KITTITAS COUNTY DEPARTMENT OF PUBLIC WORKS

MEMORANDUM

TO: Trudie Pettit, Community Development Services
FROM: Christina Wollman, Planner II *CW*
DATE: April 10, 2008
SUBJECT: Sunset Farms Plat P-07-60

Project	SUNSET FARMS	
Title	SITE PLAN	
Client	GENE LAMOUREUX	Project No. 1074100

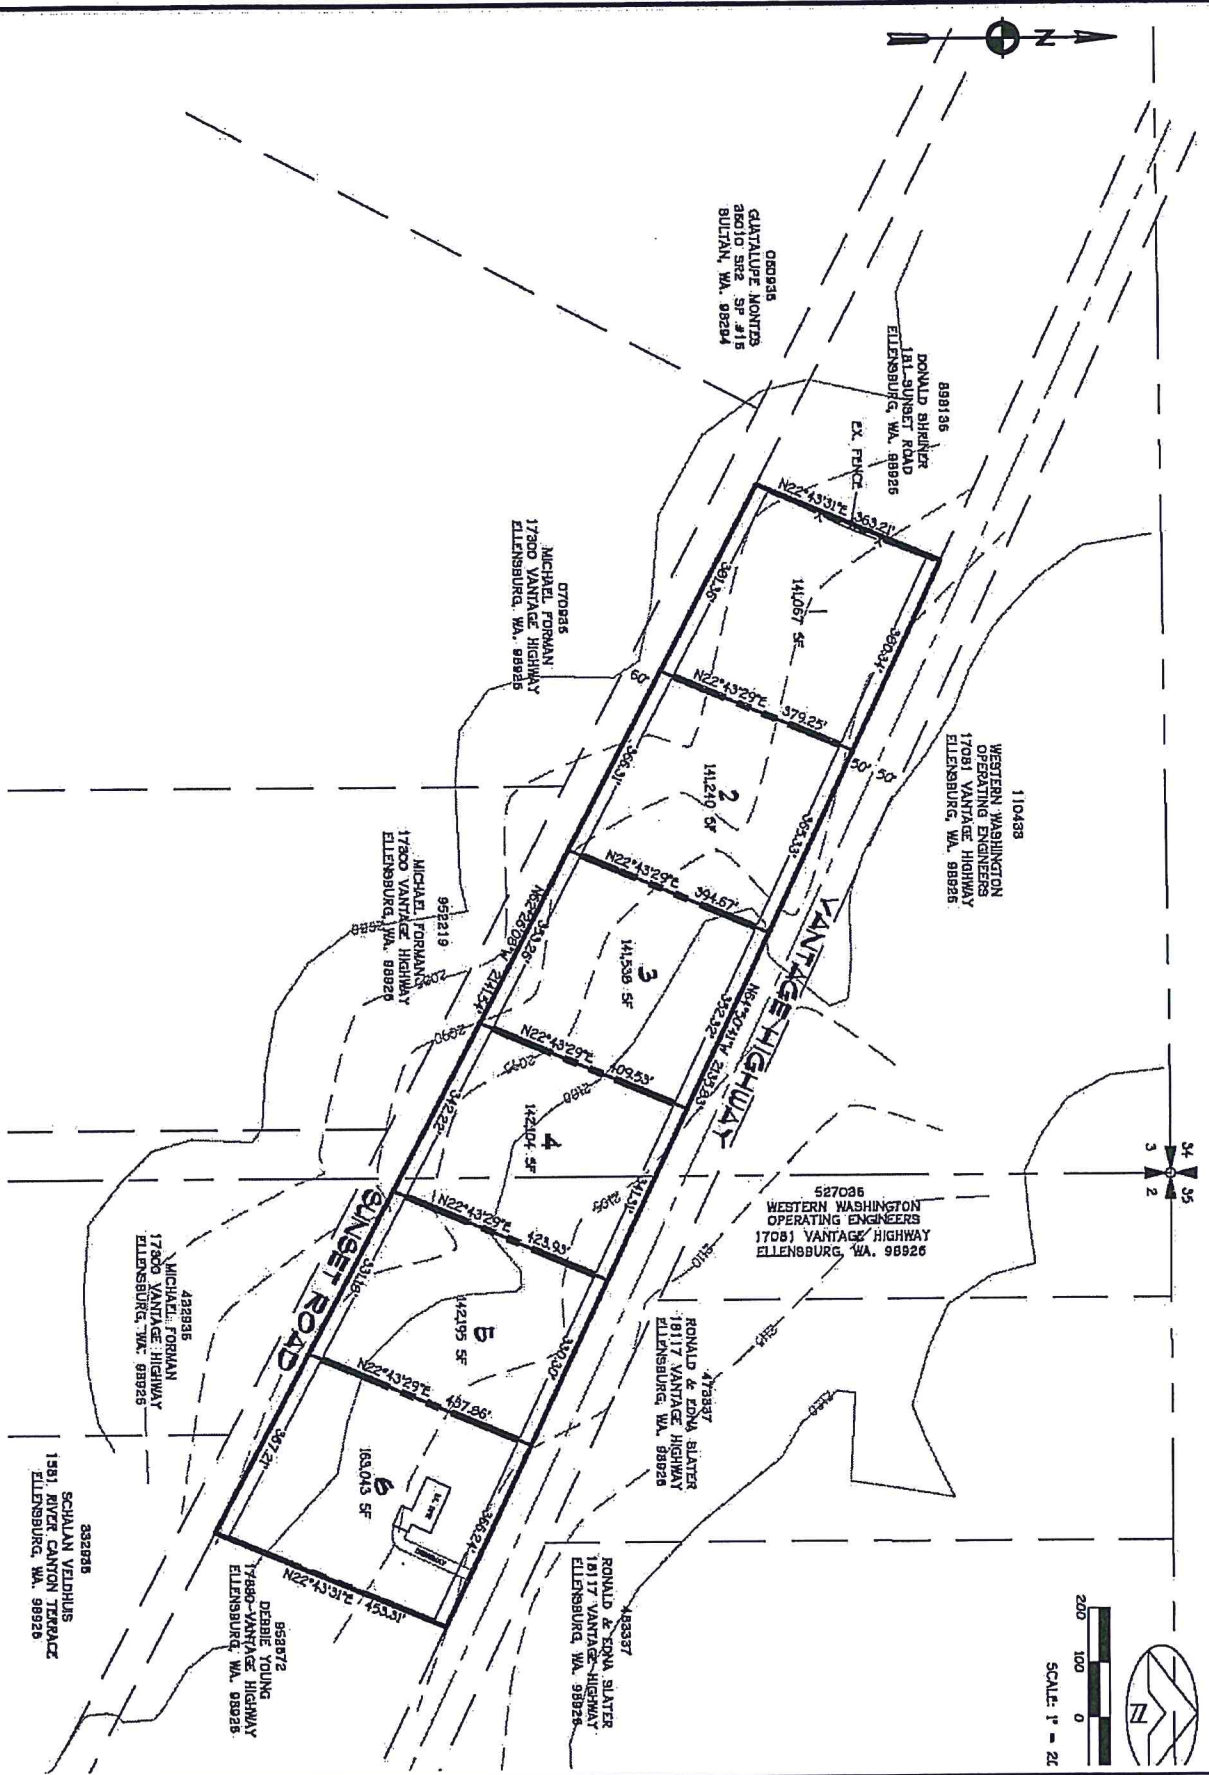
1. **Access Spacing:** Vantage Highway is classified as a Rural Minor Collector and has a minimum access spacing of 300'. The most current survey, dated February 27, 2008, does not meet this requirement. The access to Lot 3 is less than 300' from the 20' easement.

3. **20' Access Easement:** The AFN for the 20' access easement shall be shown on the face of the plat.
4. **Joint-Use Driveway:** A joint-use access shall serve no more than two tax parcels. See Kittitas County Road Standards, 9/6/05 edition.
